Our Ref: MA08365-1

Date: 1 September 2010

RE: PREFERRED PROJECT REPORT – WALLACE WURTH BUILDING (MP 09_075)

GFA LEVEL 3: 2,675 m² 1 Level 3 1:400

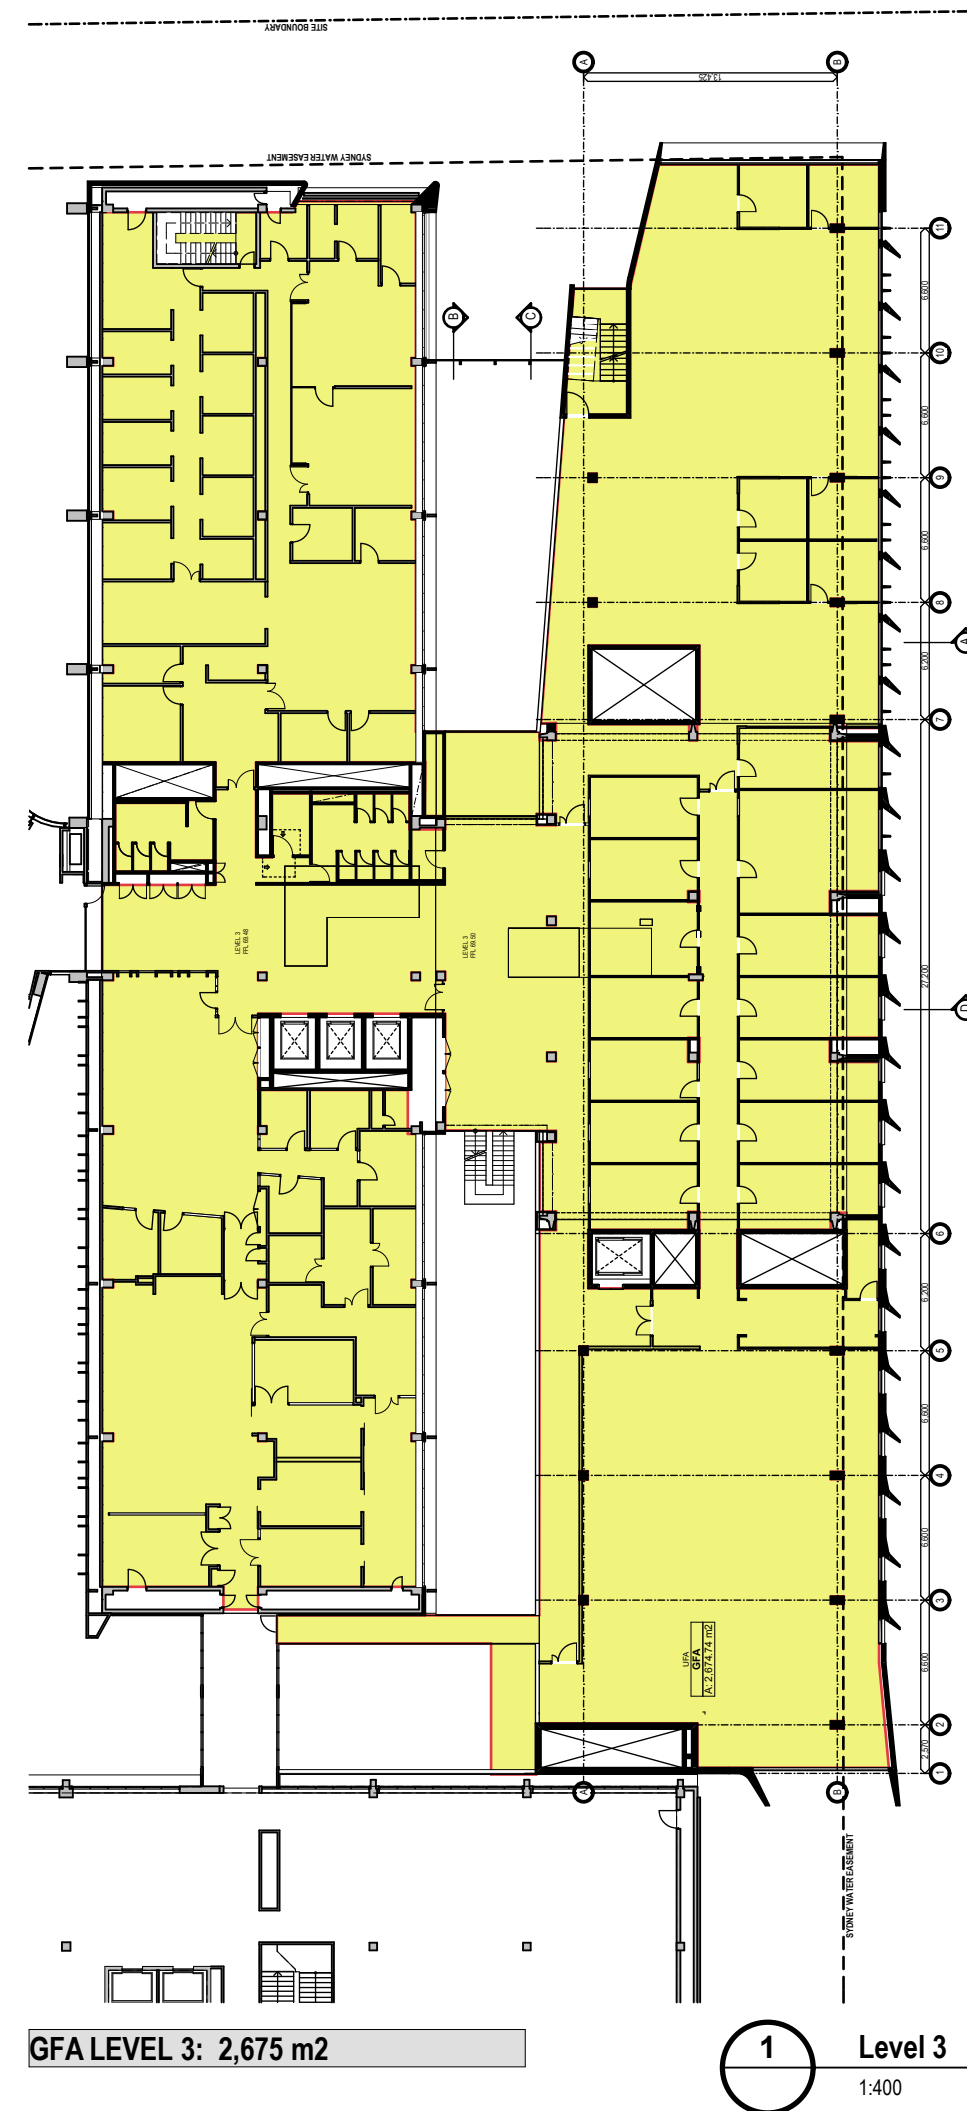
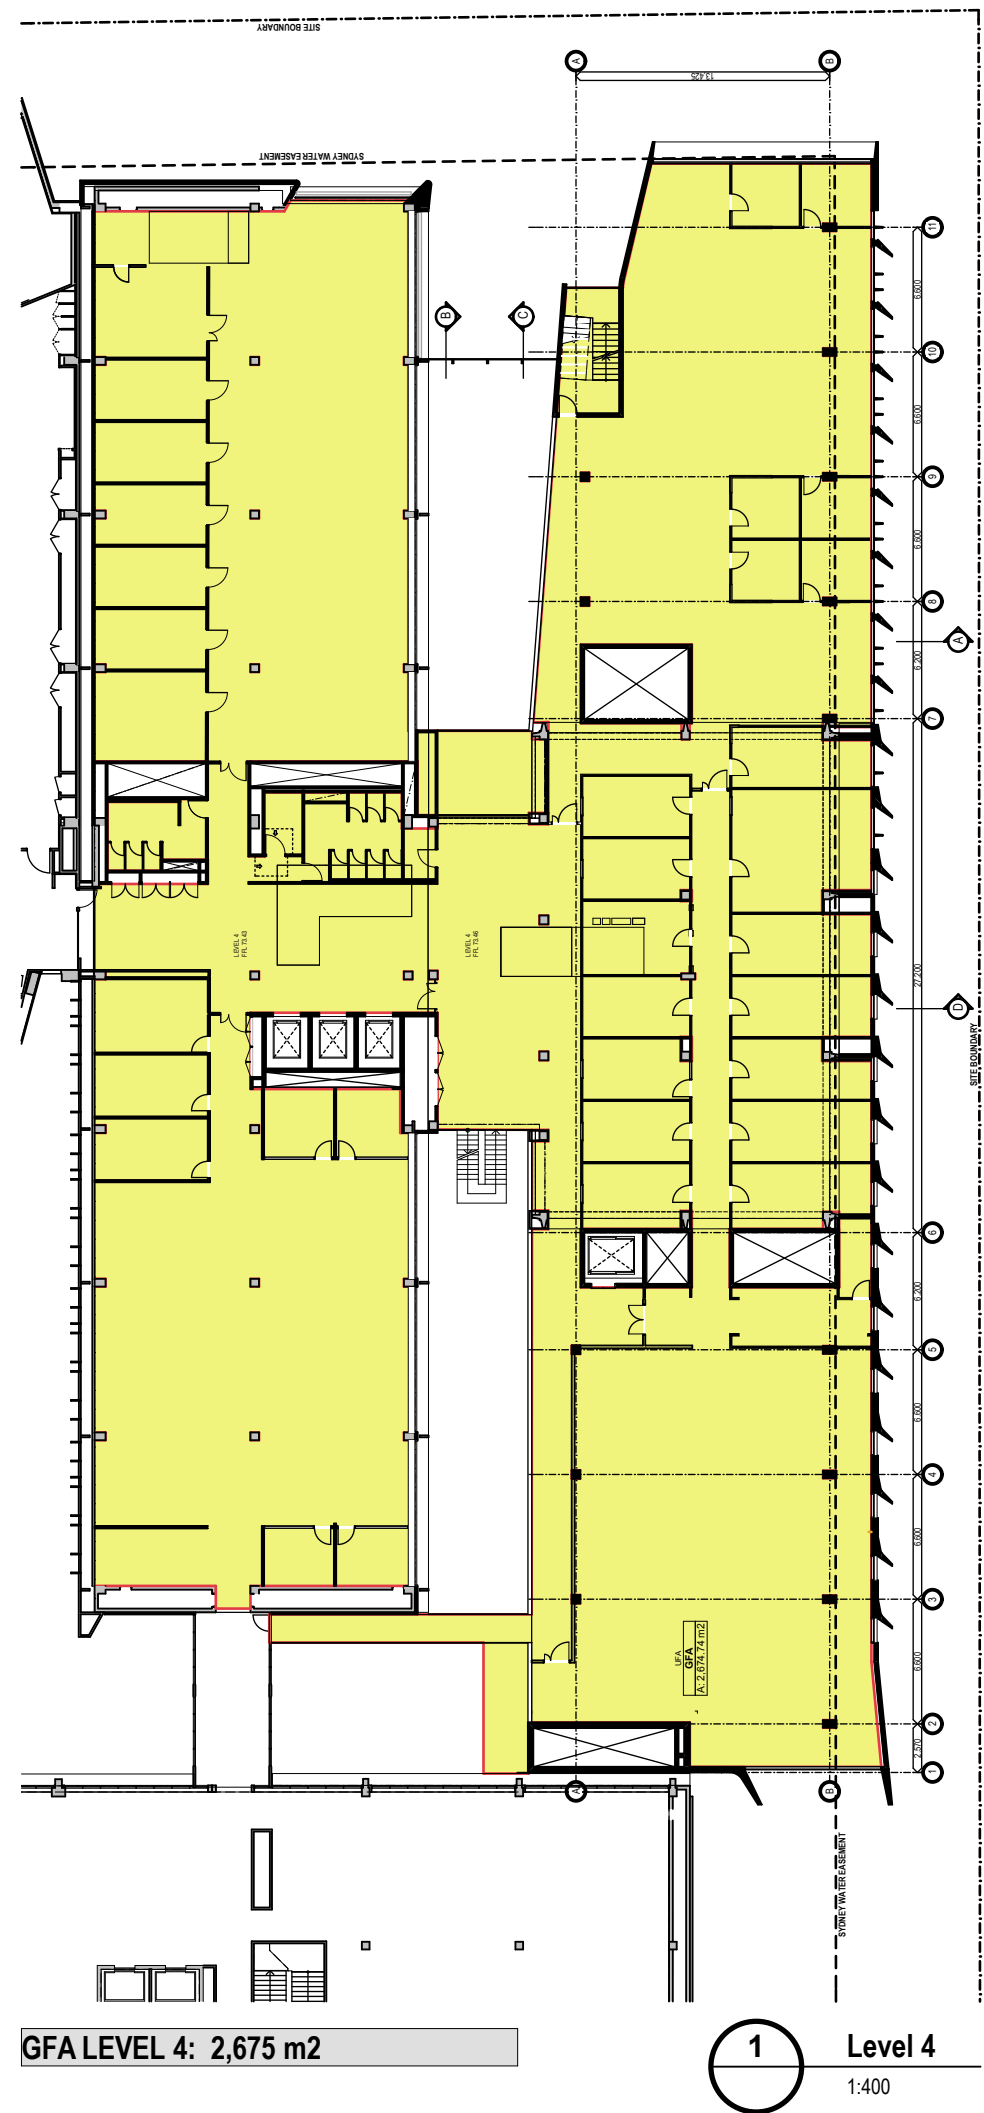
Some minor amendments have been incorporated into the overall design of the building. These include amendments to the atrium within the southern section of the proposed building, minor changes to accommodate a fire stair to the lower ground floor and some subtle changes to the north and east elevations (refer amended plans in **Attachment 4**).

The design amendments for this part of the atrium propose to reduce its height to Level 3. A new façade “skin” is proposed on those parts of the Biological Sciences building that would be visible from within the proposed Wallace Wurth Building following the amendments to the atrium (i.e. the ground floor, level 1 and level 2).

The new atrium roof will comprise a concrete slab, overlain with a membrane and stone ballast to enable drainage. Skylights are also proposed along the southern boundary adjoining the Biological Sciences Building to maximise solar access to the levels below.

1 Cross Section A
1:100

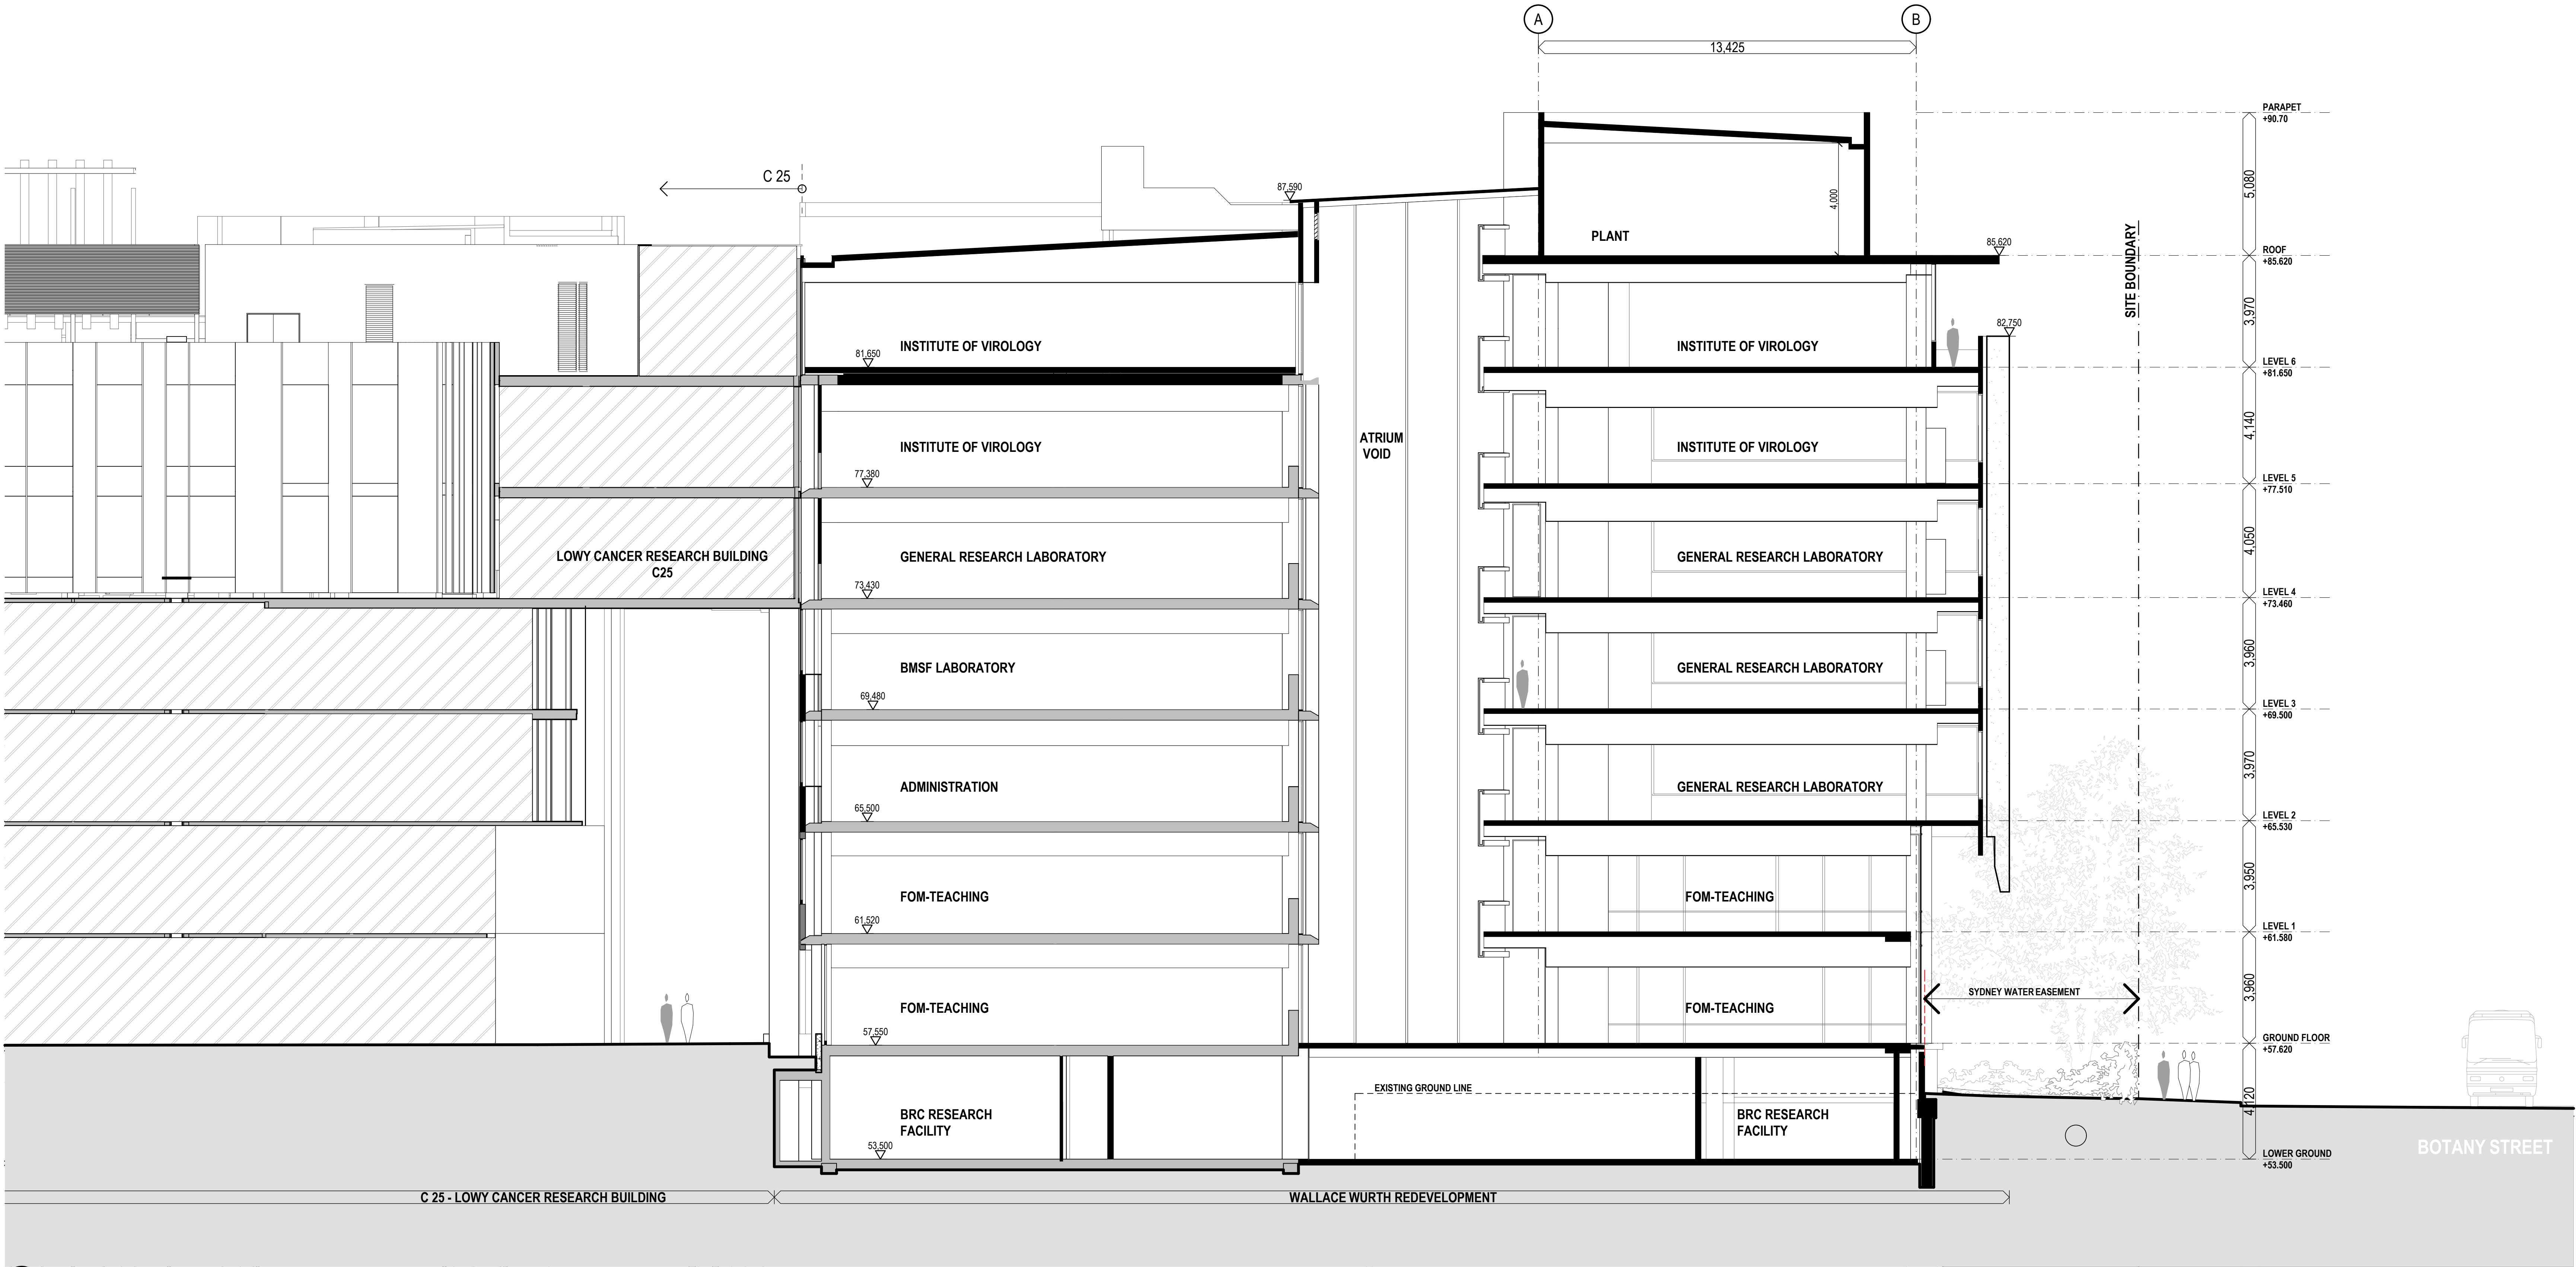
- The planter structure along High Street presented a significant structure within the easement zone and was unlikely to be supported. The plans have since been amended to move the planter structure out of the easement, as per the attached section (**Attachment 1**). These have been provided to Sydney Water for comment. A condition of consent requiring Sydney Water approval of final designs is considered an appropriate mechanism to deal with any further issues in relation to the proposed encroachment. This has been communicated to Sydney Water and it is requested that Council seek to liaise with them in formalising this arrangement.
